Red Text = The El Paso County Comments Rev. 0

Green Text = The Engineer of Record answers on the El Paso County Comments Rev. 0 for Variance of Use project

PROJECT NAME:
**VARIANCE
OF LAND USE**

PROJECT ADDRESS:
1185 N Curtis Rd,
Colorado Springs, CO
80930

SHEET NUMBER:
 S-3

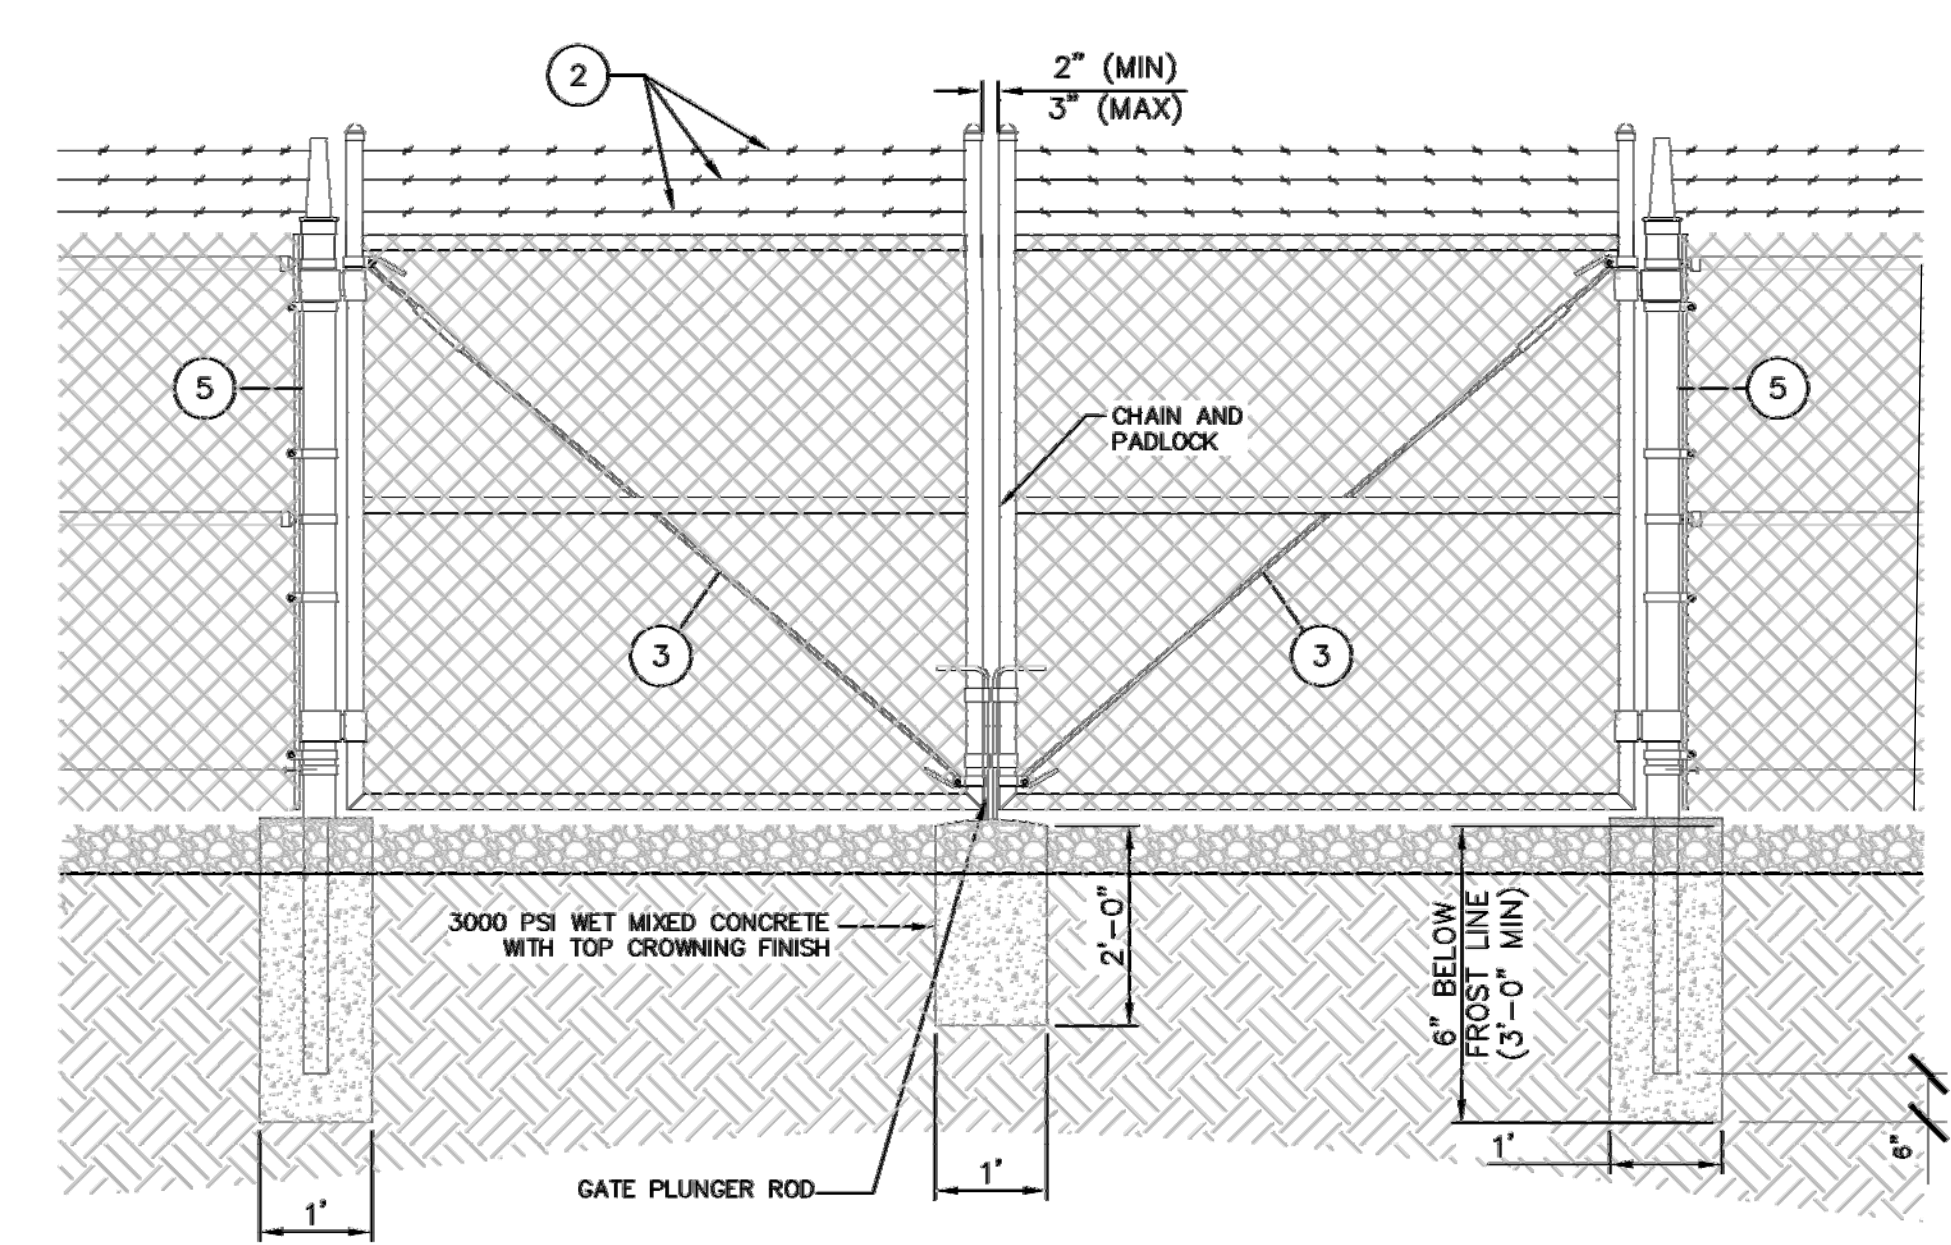
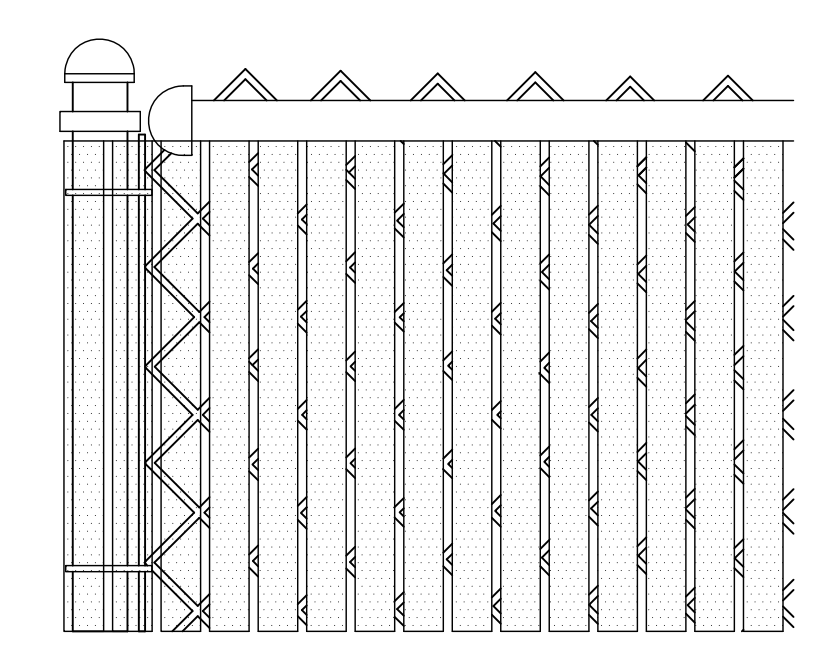
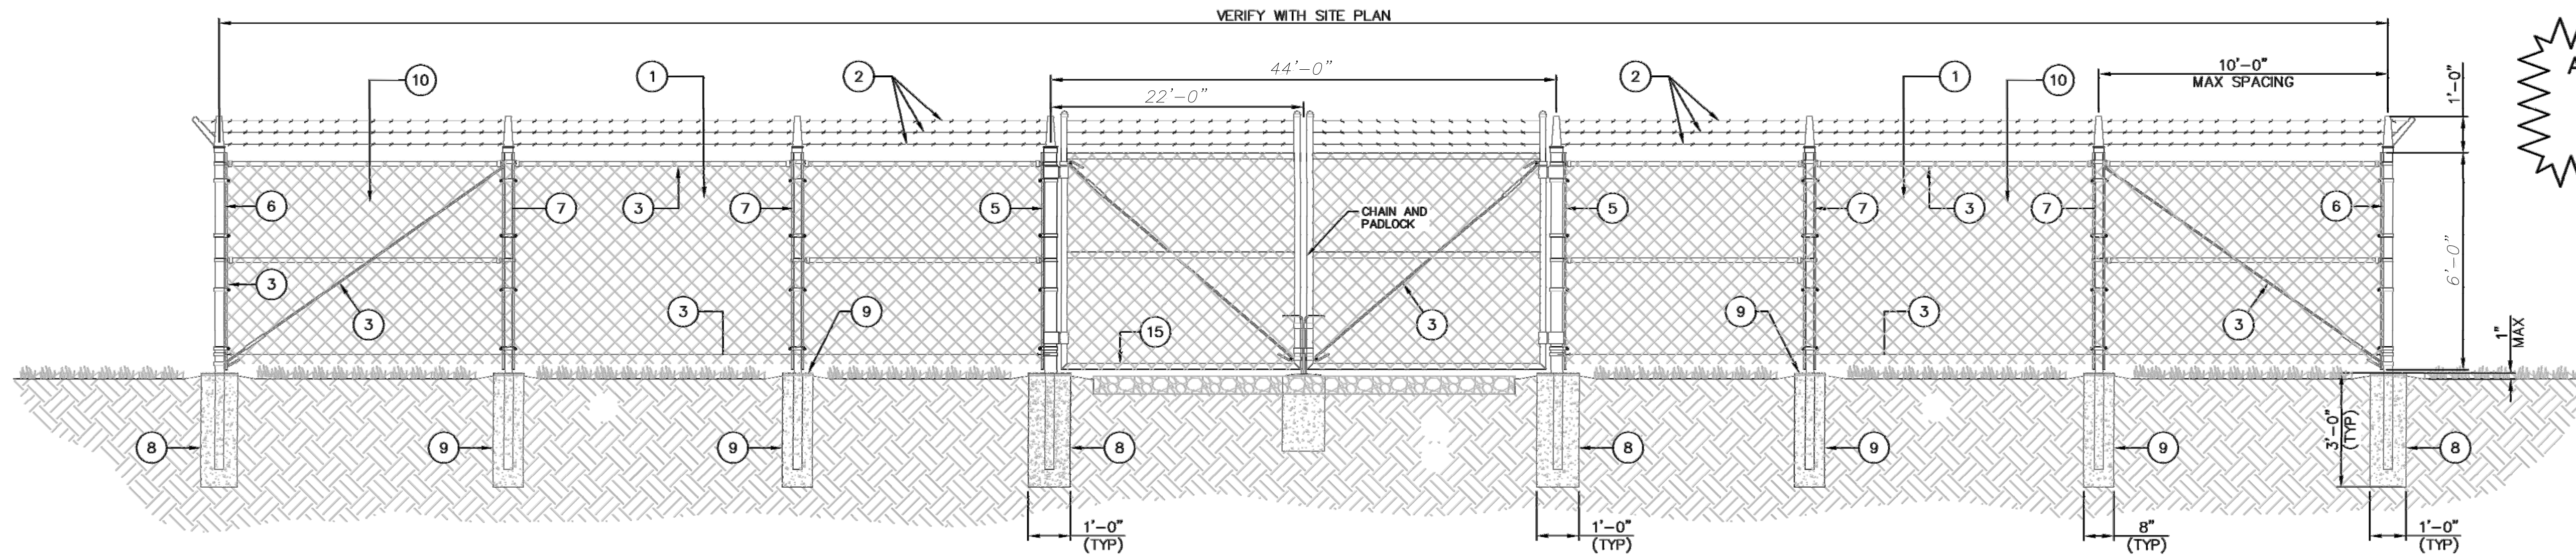
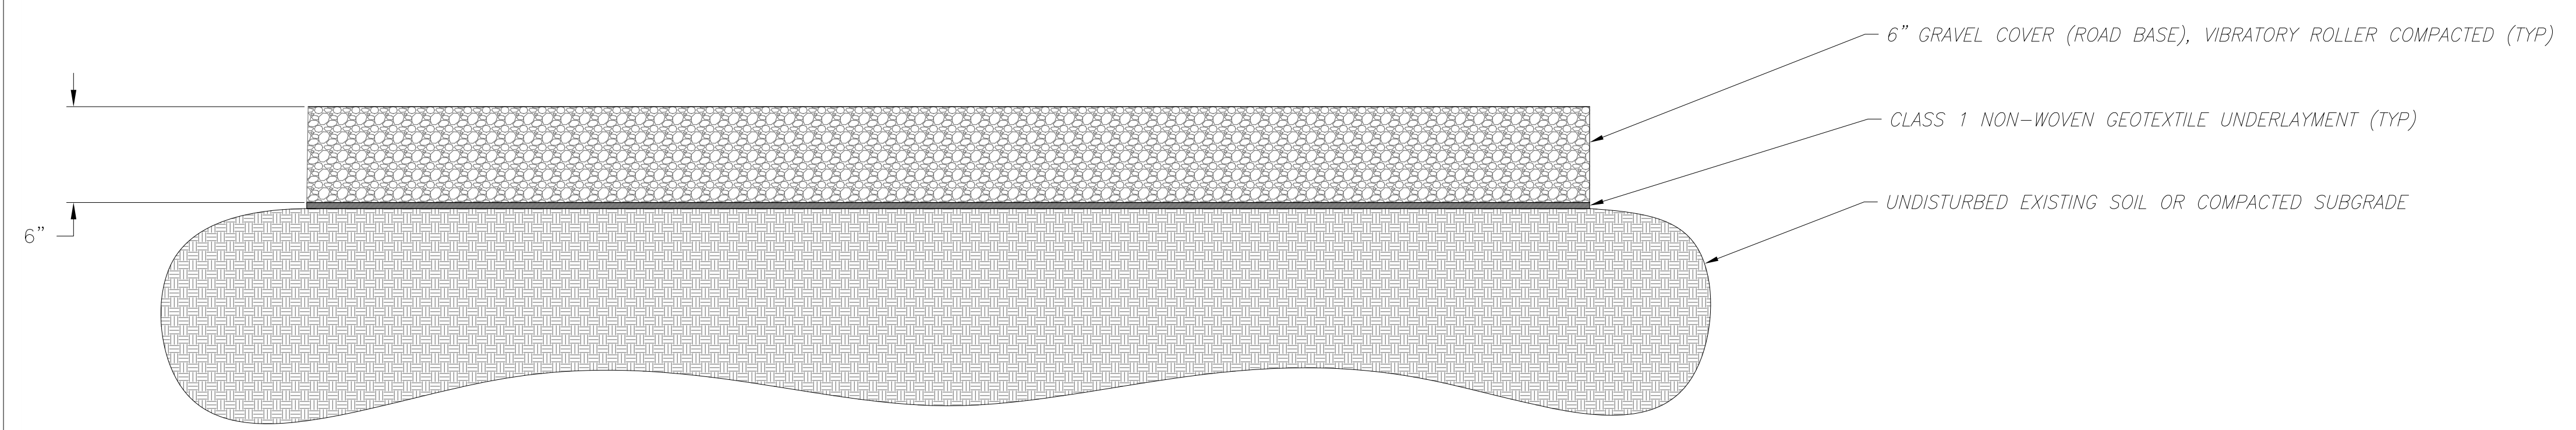
32. Please update fencing to reflect requirements of code:

(2) Materials Screened by Solid Fence or Vegetation. Outside storage shall be enclosed and concealed by a solid fence or wall at least 6 feet in height or any combination of berming, shrubs, trees fencing or walls which will provide at maturity a minimum of 6 feet of height and 100% opaque screening for the area utilized for outside storage.

Fence screening material?

- ✓ Fencing is update to reflect requirements of code as presented on Sheet #: S-3.
